Date: 17 October 2024  
Your Ref: EN070009  
Document Ref: 7.2

## THE H2TEESSIDE PROJECT

### REQUEST FOR PROPOSED CHANGES TO THE H2TEESSIDE DEVELOPMENT CONSENT ORDER ('THE H2TEESSIDE ORDER') APPLICATION

H2 Teesside  
 Viewpoint 2: The Cliff, Seaton Carew  
 Figure 16-7-1b Proposed

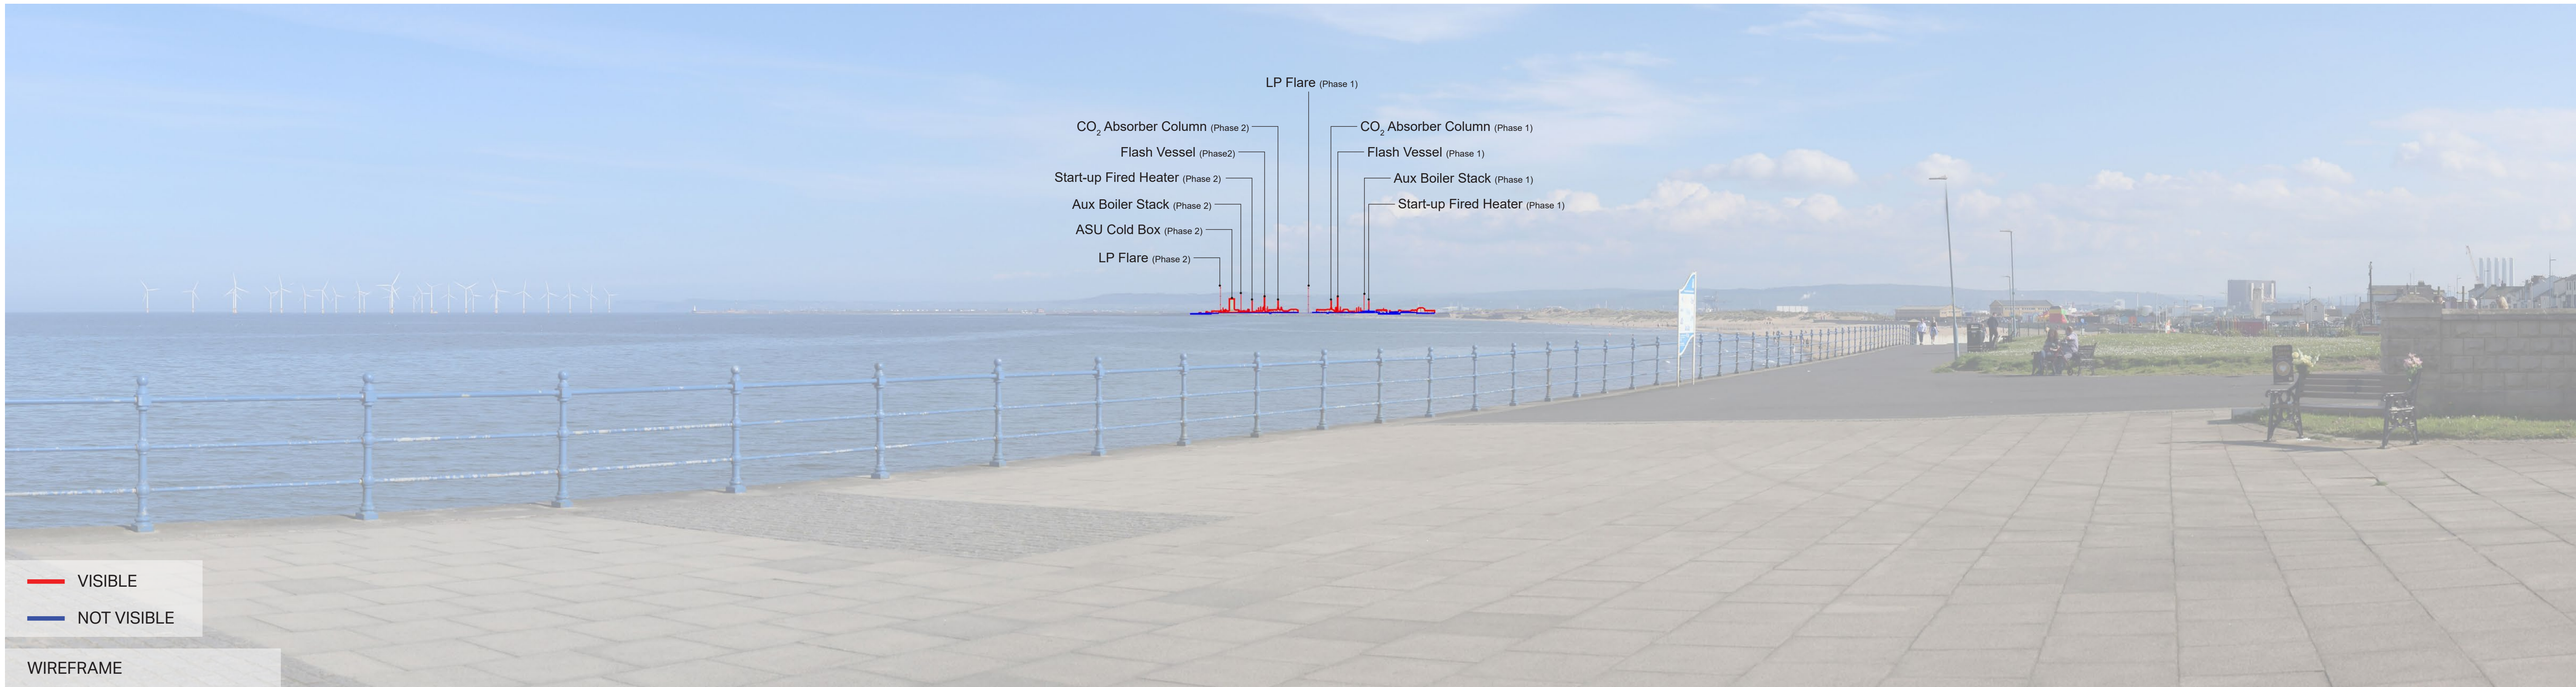
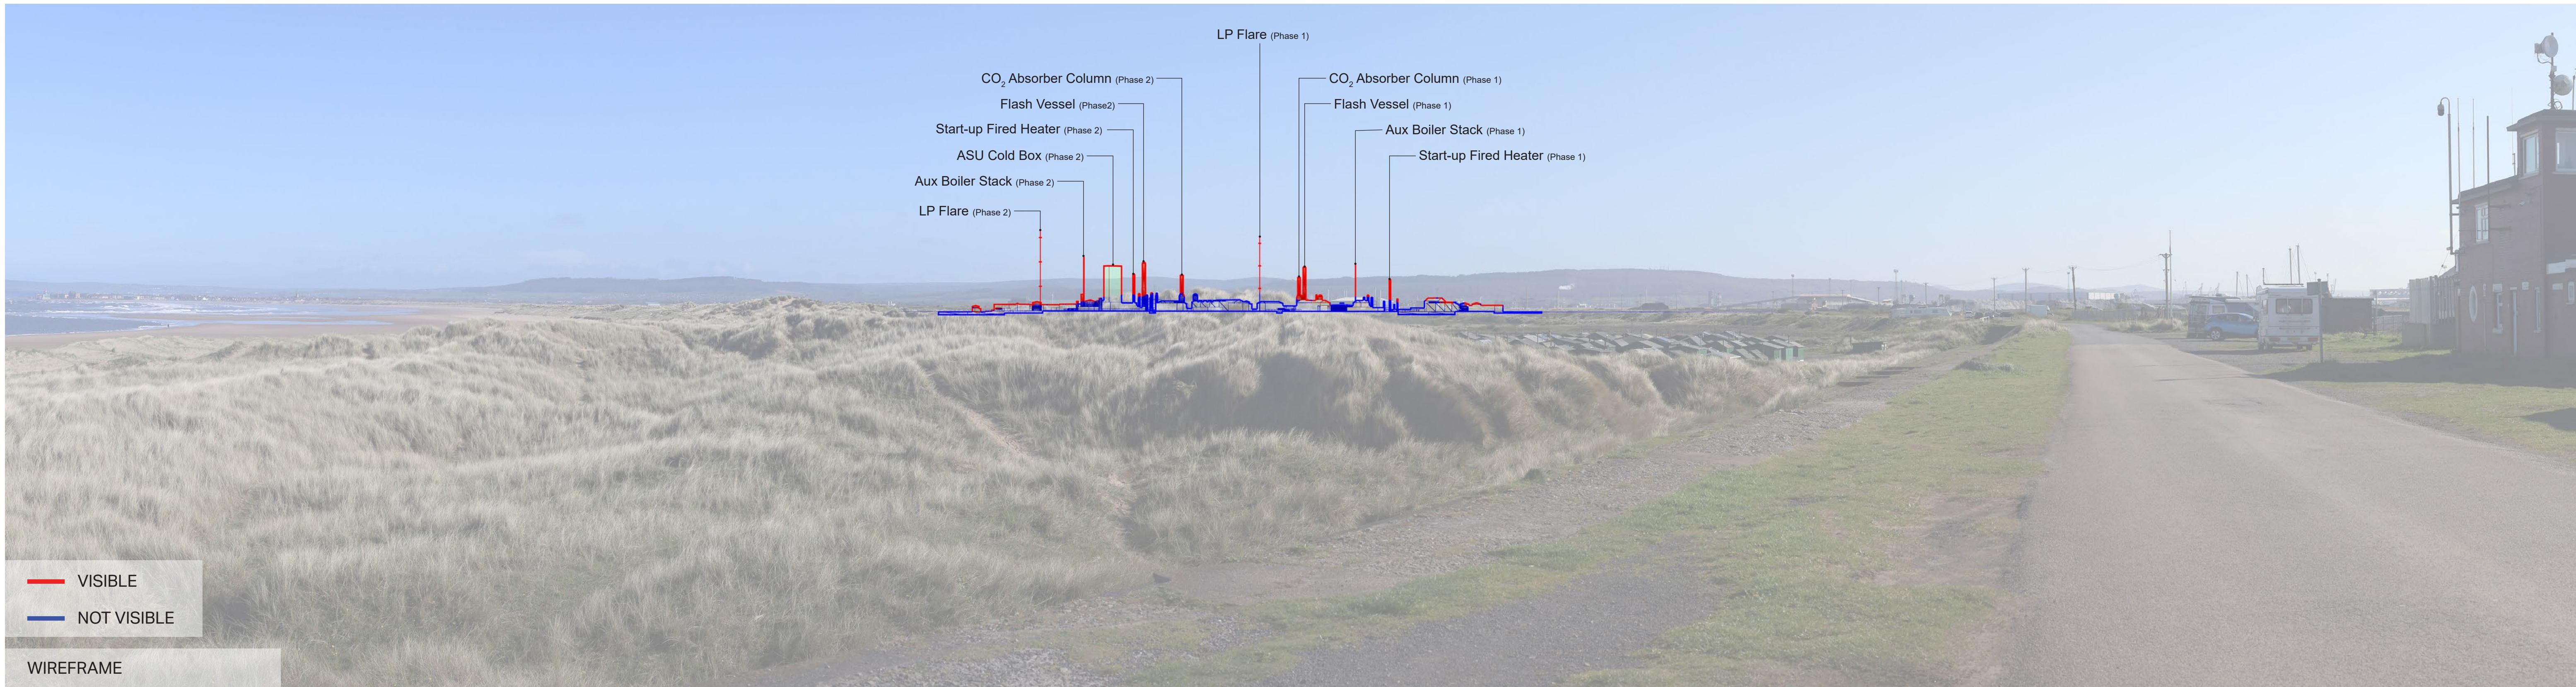
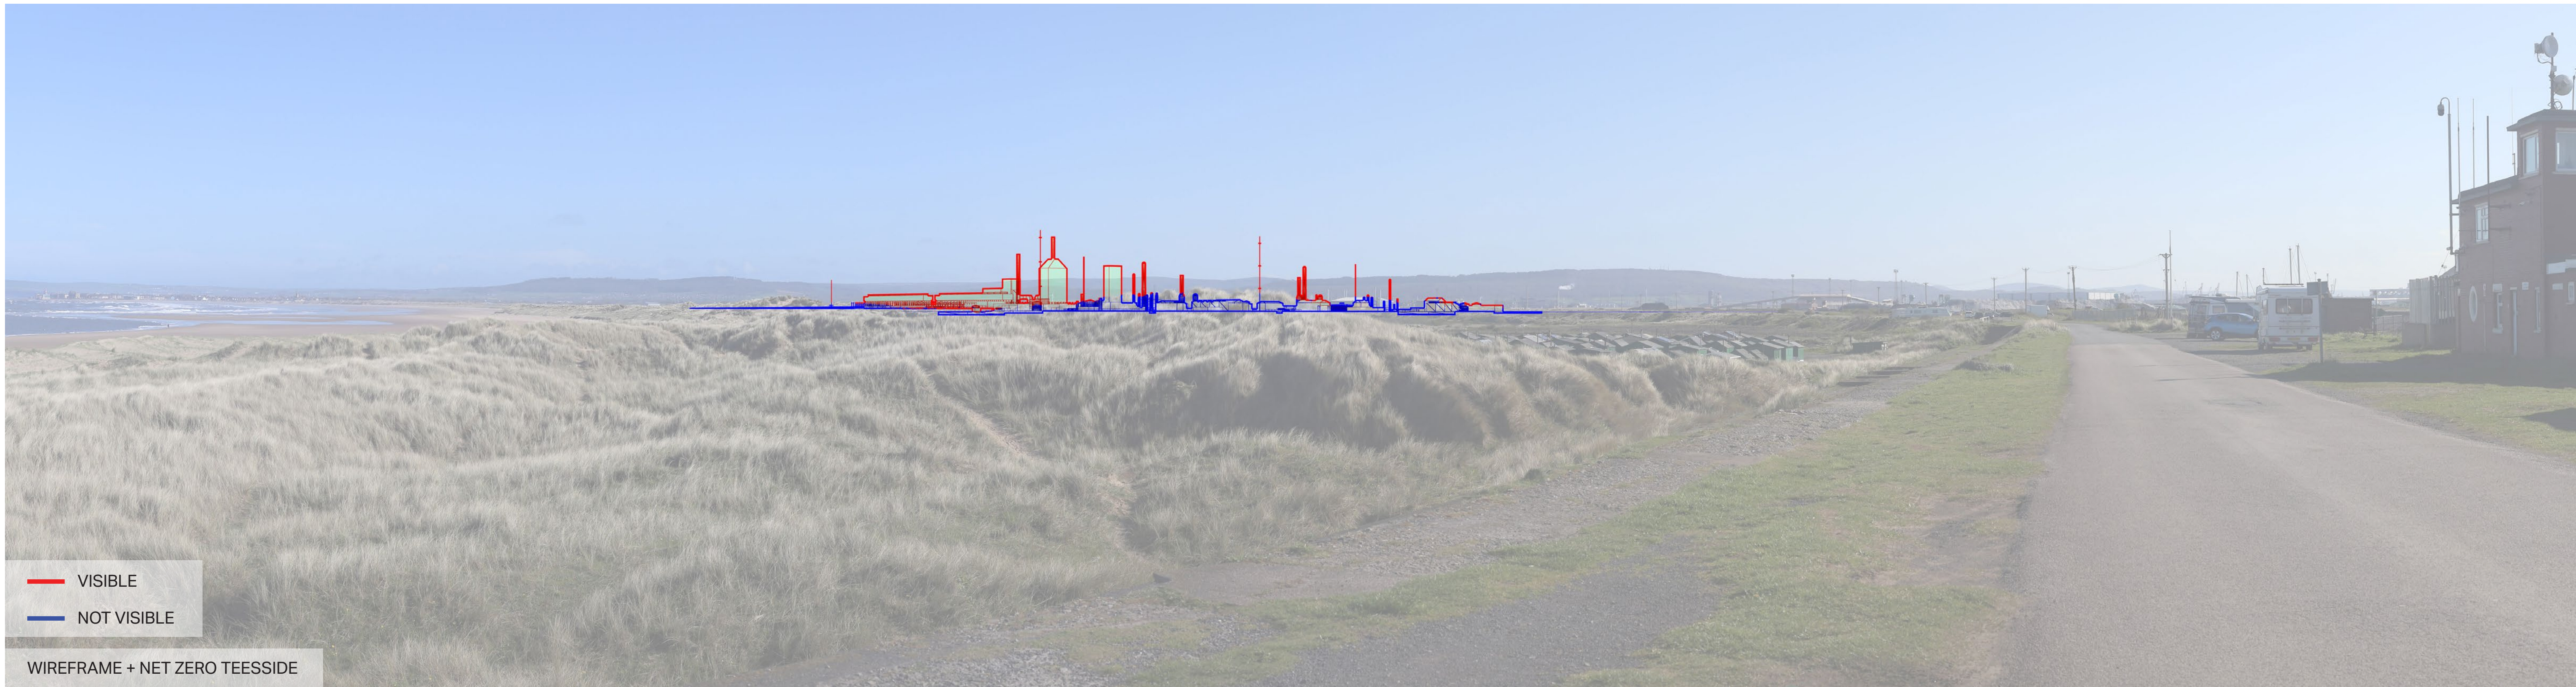
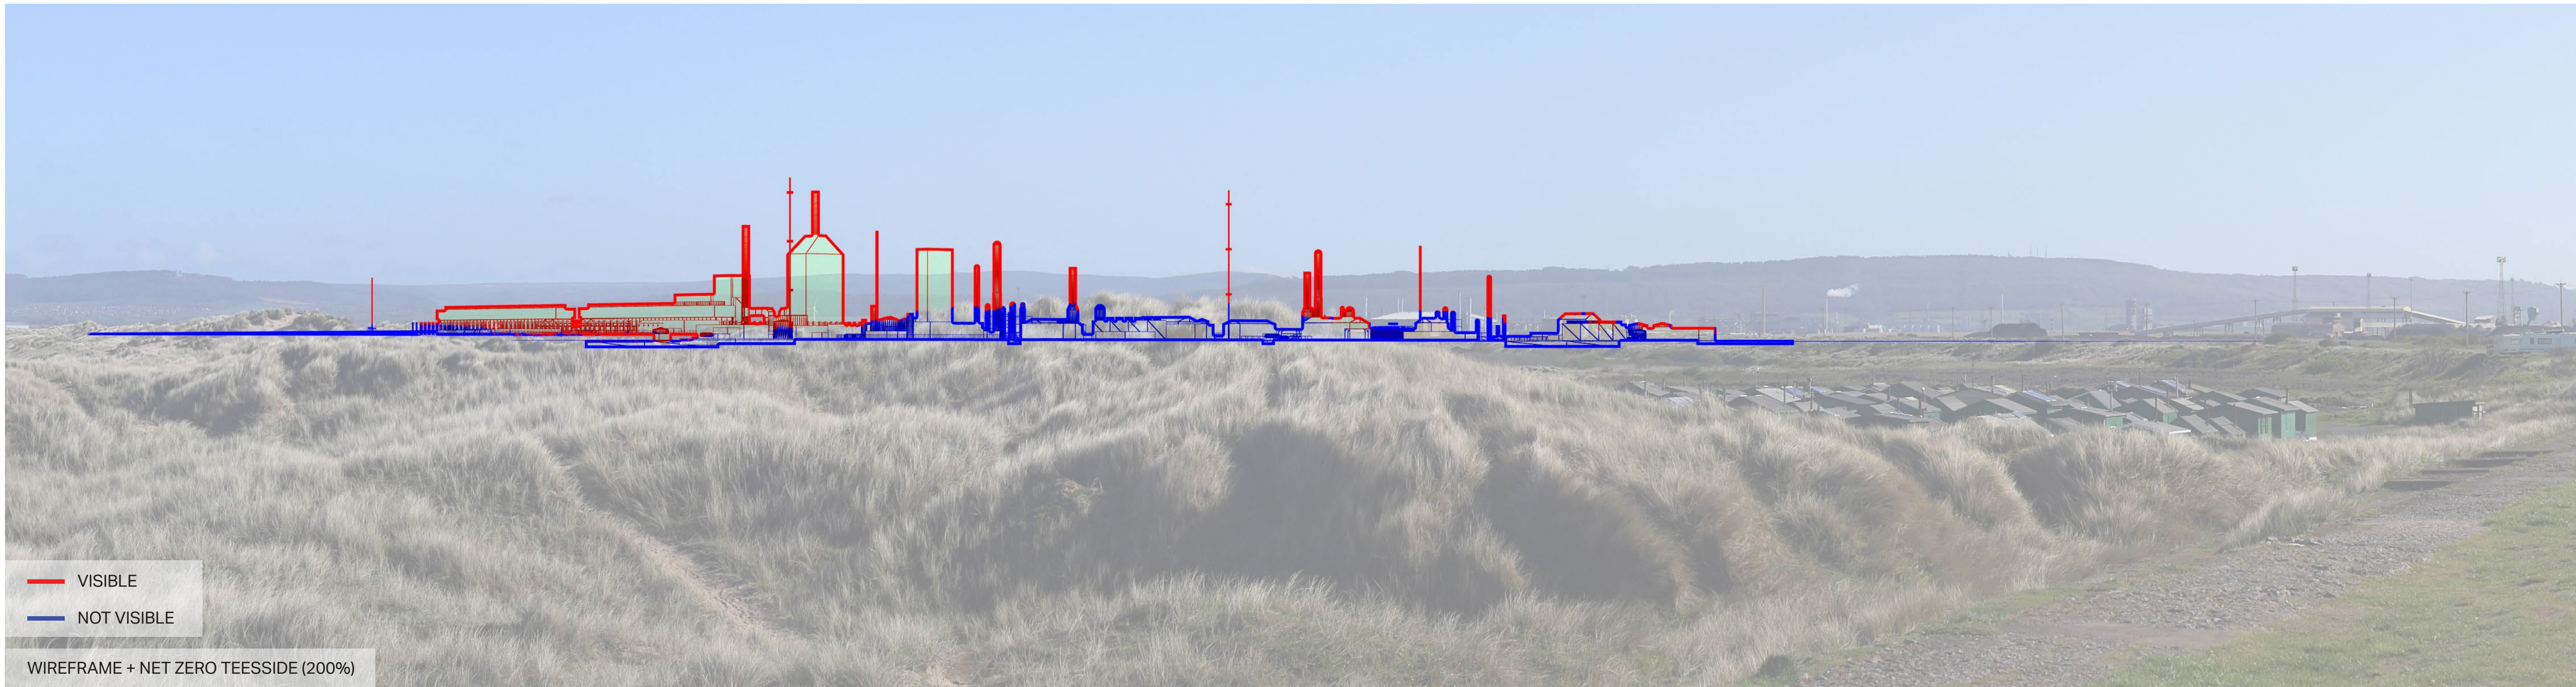
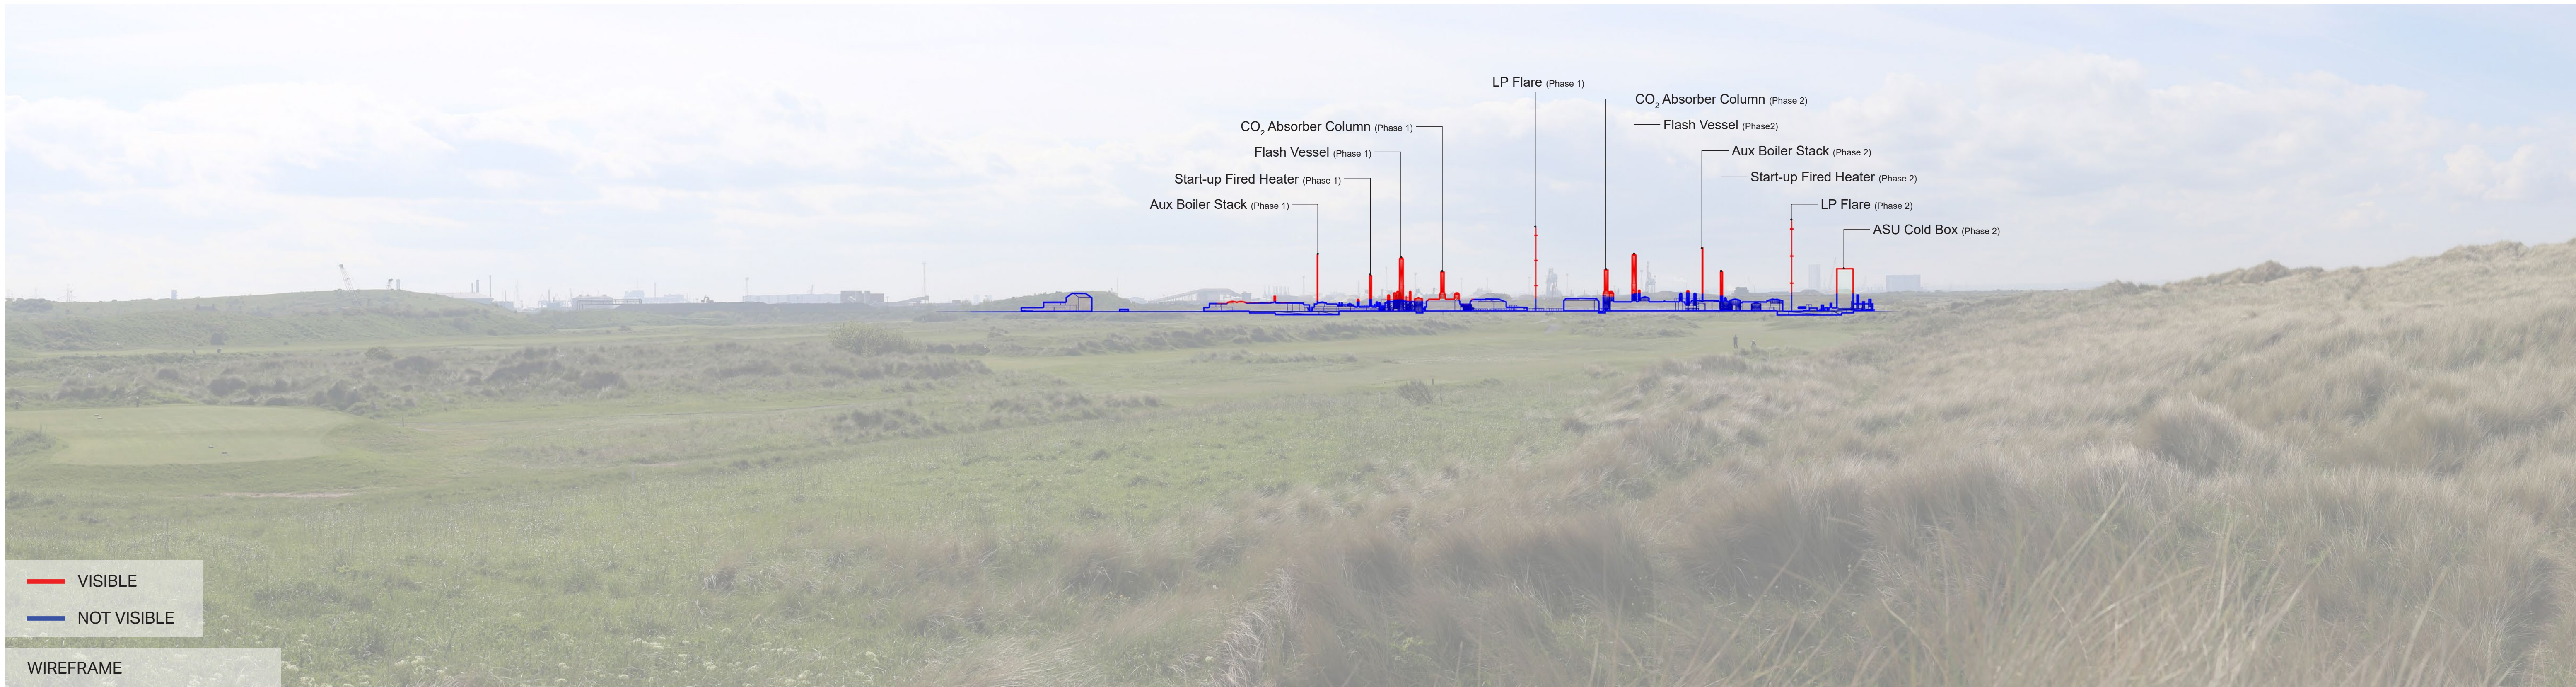
However, the Applicant has noticed an error with those photomontages and so is submitting updated revisions of these, which show one flare (i.e. the 'pre-changes' position). These have been submitted as an update to **Revision 2** [AS-030] – which we propose to call **Revision 3**.

The error in question was an incorrect representation of dimensions from the initial plot plan in relation to the flare. No changes to the dimensions are presented, only the interpretation of those numbers has been revised. Specifically, the flare was initially visualised inaccurately, suggesting a much more obtrusive structure. In reality, there is no wide platform below the flare. Instead, the flare consists of a 1 m diameter structure with a staircase running to the top.

It should be noted that as part of the Change Application, the Applicant has also submitted '**Revision 4**' of the figures. These show two flares (further to Change 1) but with those flares visually represented consistent with the 'base' **Revision 3** referred to above.

If the Change Application in respect of Change 1 is accepted by the ExA, **Revision 4** of the photomontages should be considered moving forward as the correct version of those photomontages. If that change is not accepted, then the updated **Revision 3**, should be considered as the correct version moving forward.
